RE: Harnett County Land Use Application HTE#08-5-20491

The Harnett County Department of Public Health, Environmental Health Division on July 30, 2008, evaluated the above referenced property at the site designated on the plat/site plan that accompanied your existing tank application. According to your application requesting a 18' x 24' den addition, the evaluation was done in accordance with the laws and rules governing wastewater systems in North Carolina General Statute 18A.1950 including related statutes and Title 15A, Subchapter 18A, of the North Carolina Administrative Code, Rule.1950 and related rules.

Based on the criteria set out in Title 15A, Subchapter 18A, of the North Carolina Administrative Code, Rules .1950, the evaluation indicated that the site is **UNSUITABLE** for the addition requested. Therefore, your request for an existing tank is **DENIED**. The site is denied based on the following:

PLOT PLAN
SCALE: 1" = 30'

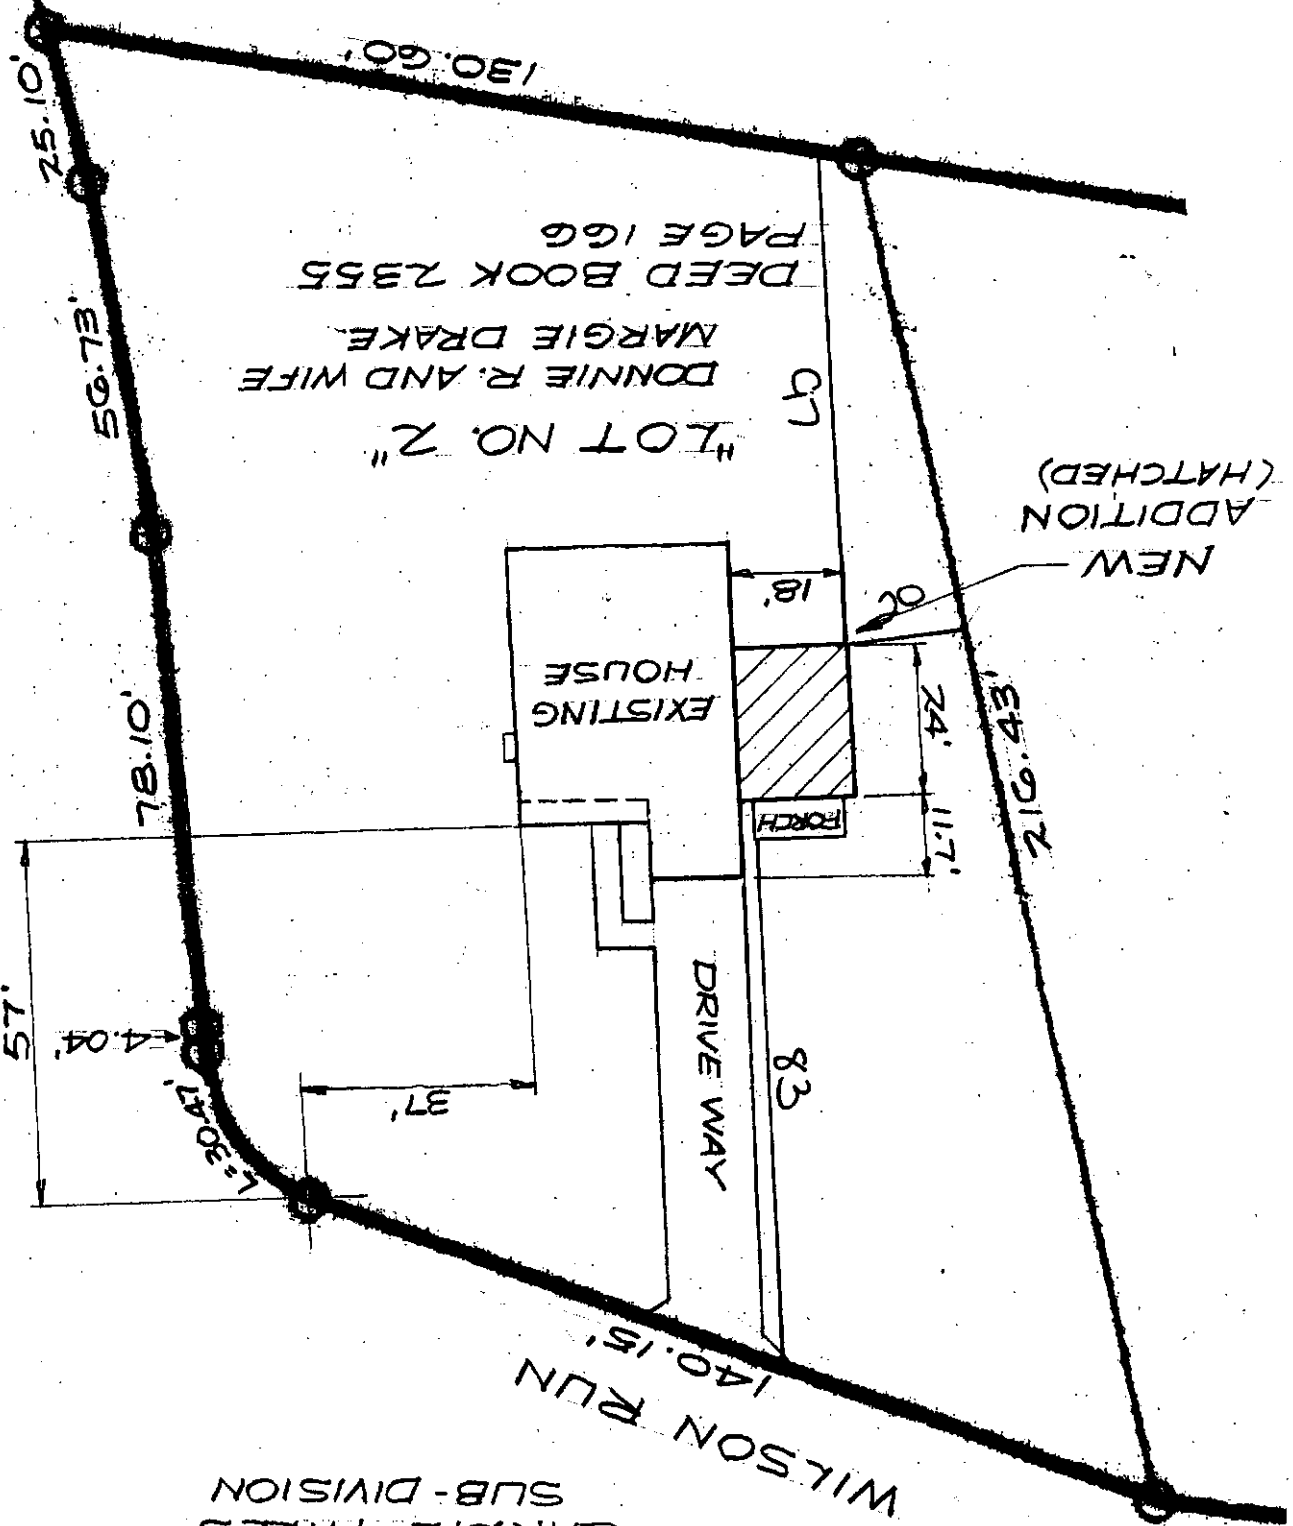
_____ 15A NCAC 18A.1950 (10) – Any building to be 5' from drain line.

Other *Your addition encroaches on the required 5' setback to a drainline*
